Your Ref: OWPC17867
Our Ref: BR/42/18/PL 08-02-2018
Please ask for:
Mr S Davis

2 No. 2 bedroom flats, one on first floor & one on second floor over existing single storey flat.

86 Annandale Avenue Bognor Regis

DRAWING
PROPOSED PLANS
DRAWING No
247/04
SCALE 1:100
DATE PER 2019
REVISION
DRAWN
CHECKED
LA

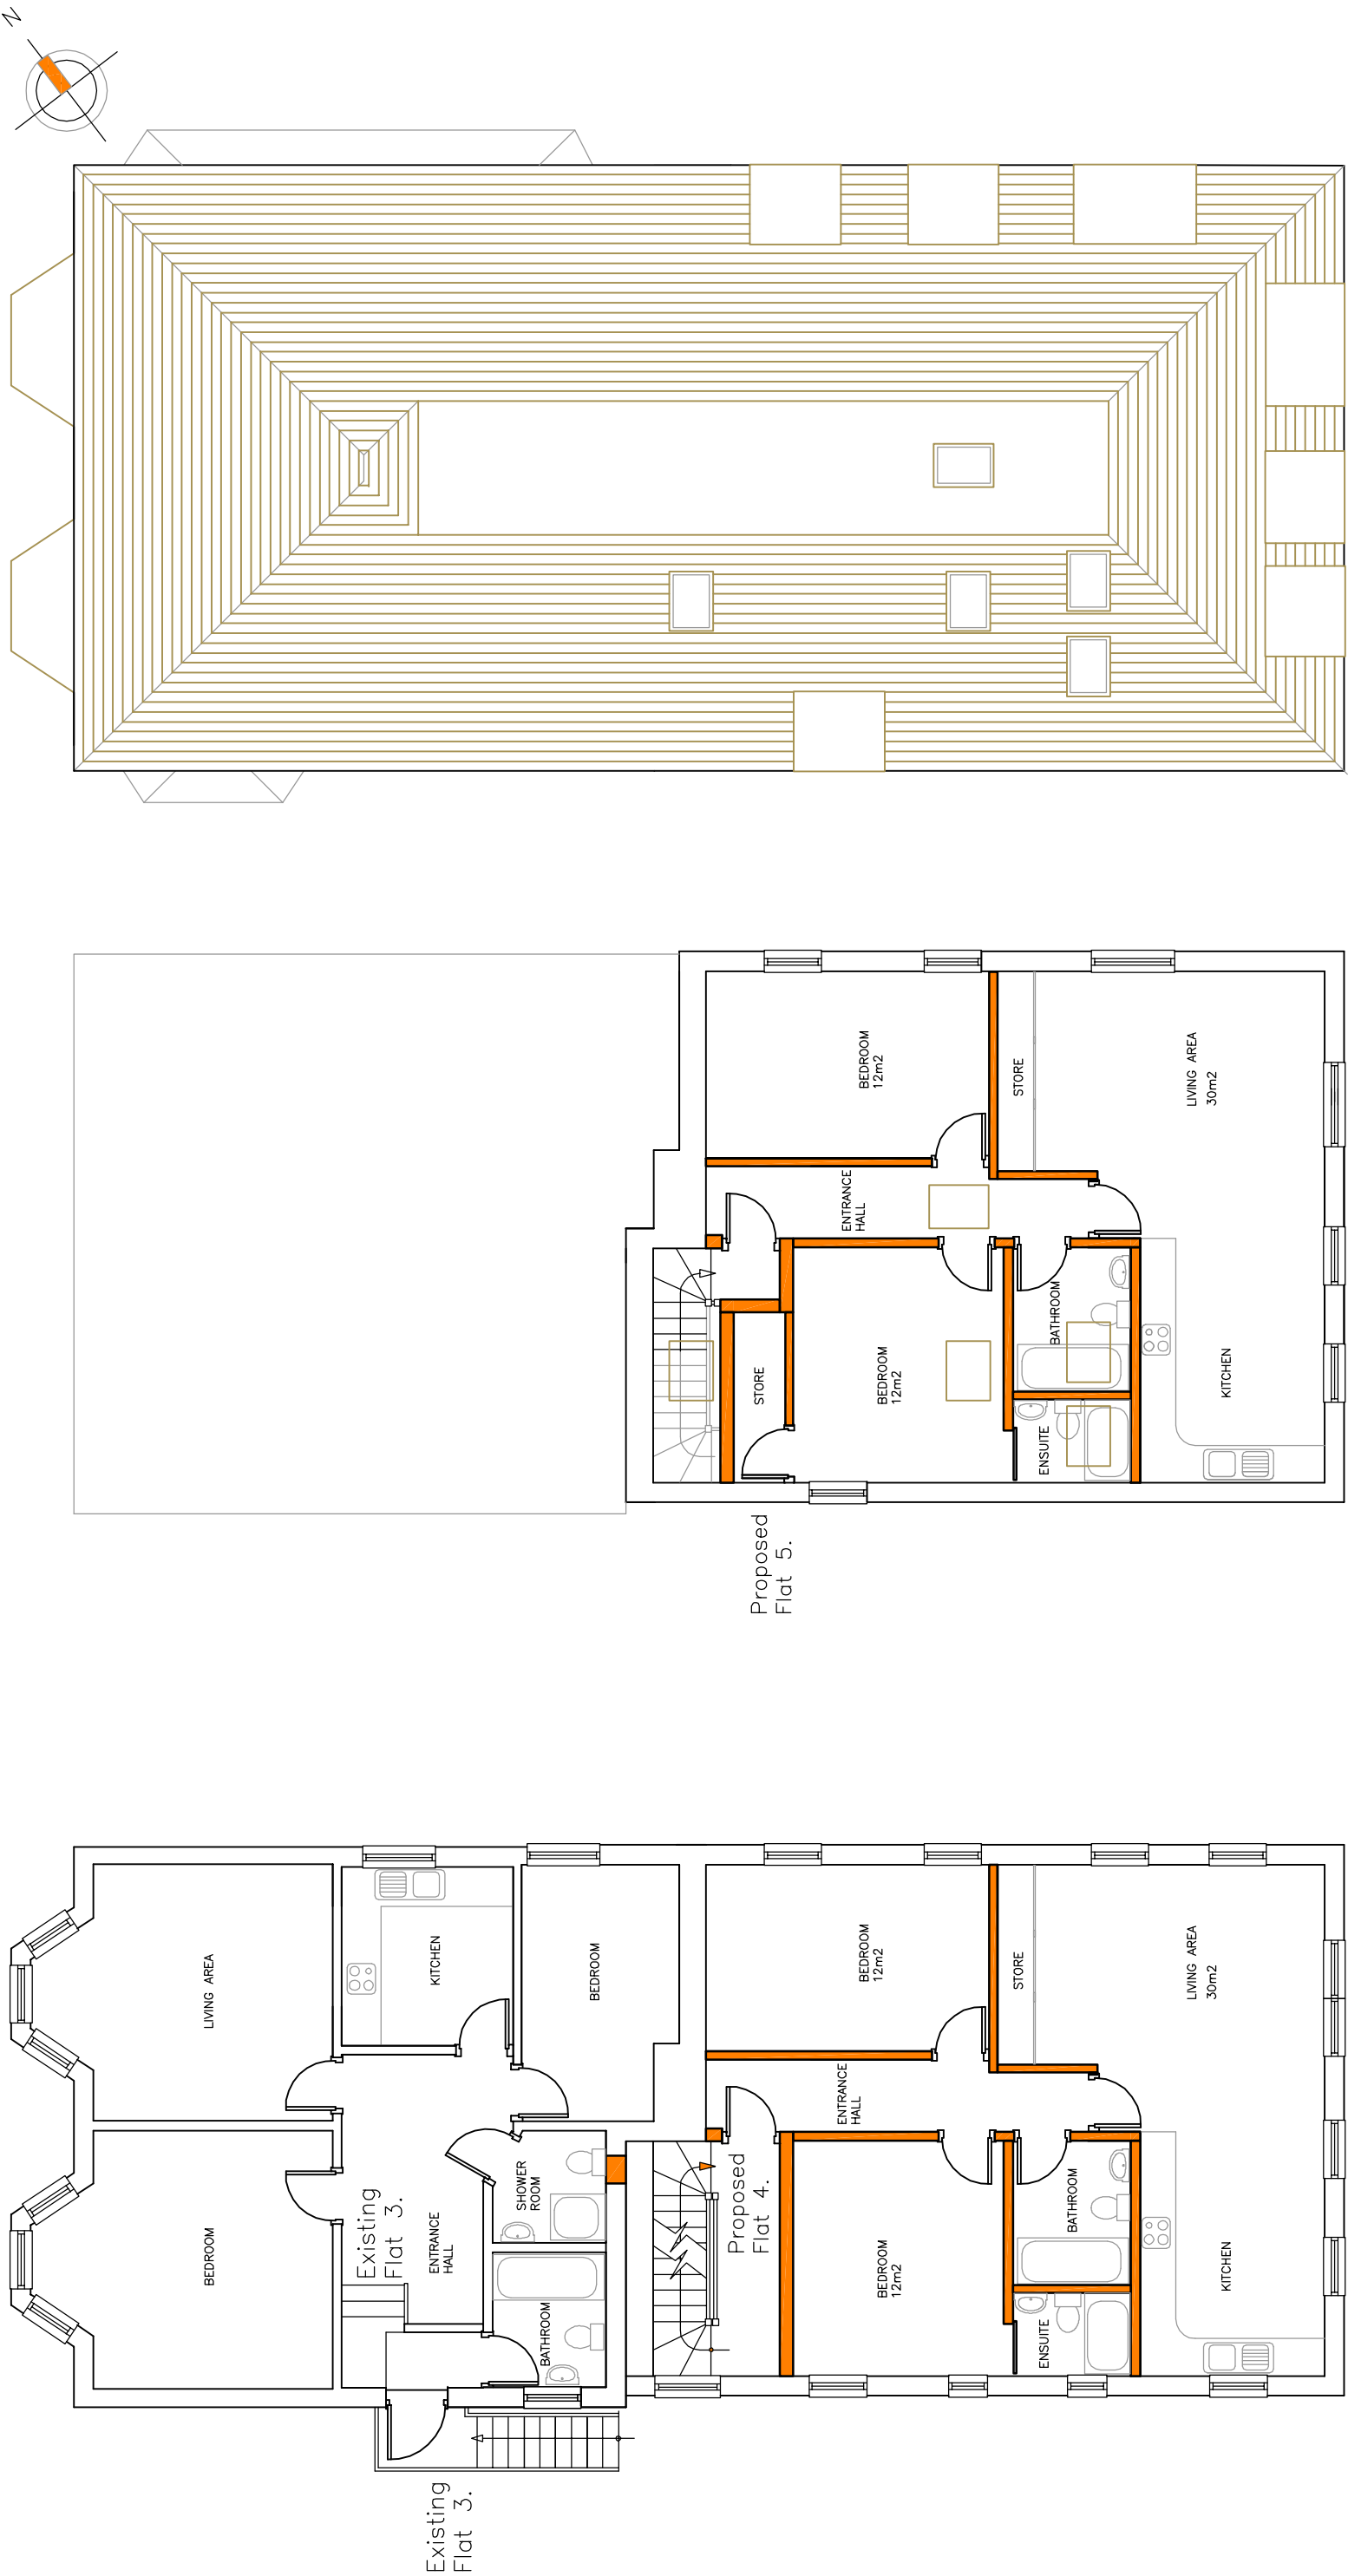
Both 84 Annandale Avenue and my own house (82 Annandale Avenue) will be completely overlooked by 6 windows and 4 Velox style roof windows. 84 Annandale Avenue will have windows looking straight into 2 bedrooms, kitchen and down stairs study. Whilst 82 will lose privacy in 1 bedroom, bathroom, kitchen, sunroom and patio area.

The design philosophy used by the architects is at best flawed, at worst a work of fabrication with regard to the development not having an adverse effect on the existing residents. 84 and 82 will as already mentioned suffer a massive loss of privacy, whilst the garden of 84 will become claustrophobic and completely overlooked.
